17 October 2018

Subject: Sydney Metro Martin Place Station Precinct: SSD 18_9347
Stage 1 Amending Development Application — response to submissions by the National Trust (NSW) and the NSW Heritage Council

Figure 52 – Proposed South OSD tower building envelope, north elevation (Martin Place) (amendment clouded red)
 Source: Grimshaw

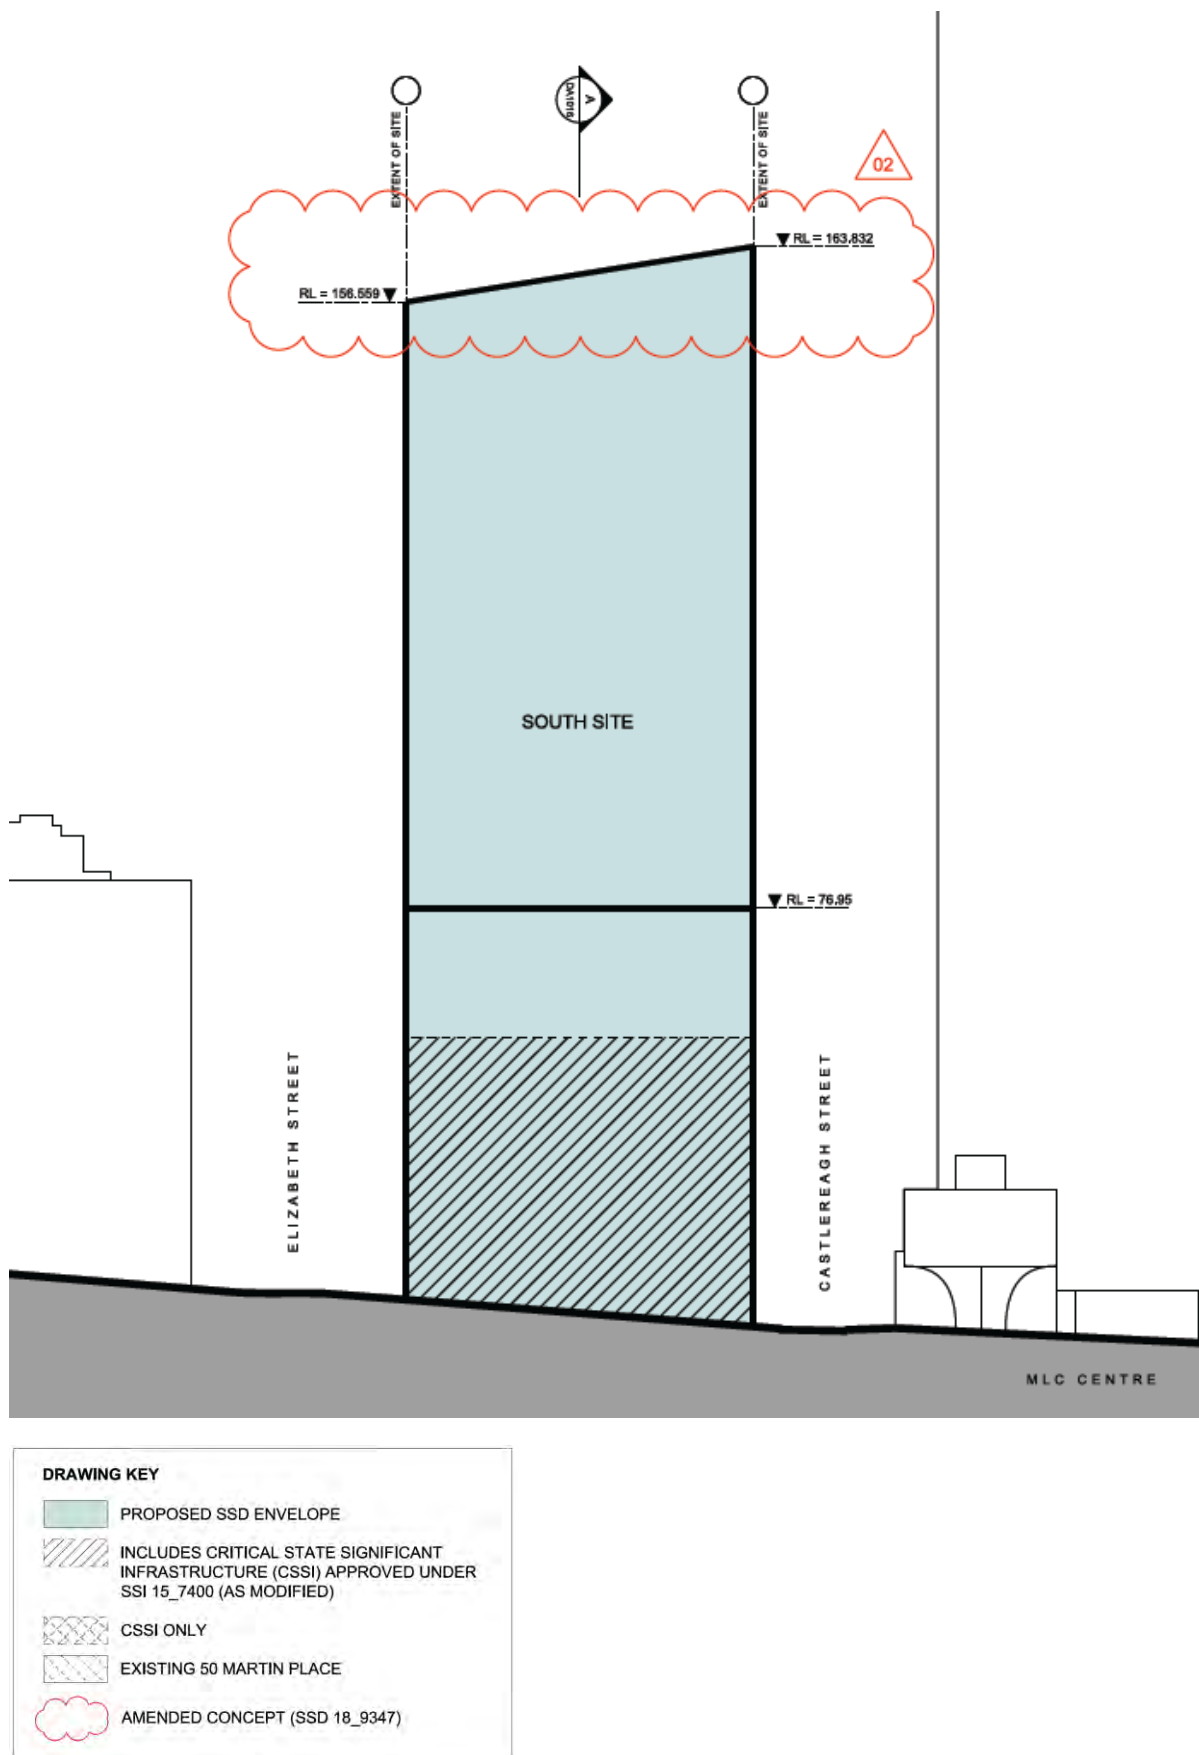
However, the reduction of the tower setback to Martin Place from 25 metres to 8 metres, is contrary to the provisions of the Sydney City Council Development Control Plan for this site and will impact adversely on the maintenance of the "very human, urban space" so vital to the public's use and enjoyment of Sydney's grand civic space.

The heritage and visual impacts of the proposed modification of the tower component of the envelope are assessed in the 'Statement of Heritage Impact', June 2018. The assessment concluded that the tower element of the proposed envelope is visible predominantly from more distant vantage points from within Martin Place. From close range vantage points, the podium element largely occupies the foreground, reinforcing the historic street wall of Martin Place.

- provide the potential for future development to conserve and enhance the significance of Martin Place as a grand civic and ceremonial space and as a valued business location; the proposed envelope will allow for the construction development of a new building which better responds to the civic and ceremonial character than the present building in scale, street alignment and height and through the setback of the tower component.

- retain and enhance the urban character, scale and strong linear enclosure of Martin Place by being built to the street alignment, having a street frontage height consistent with the prevailing building height and by setting the tower above the podium back from the street alignment.
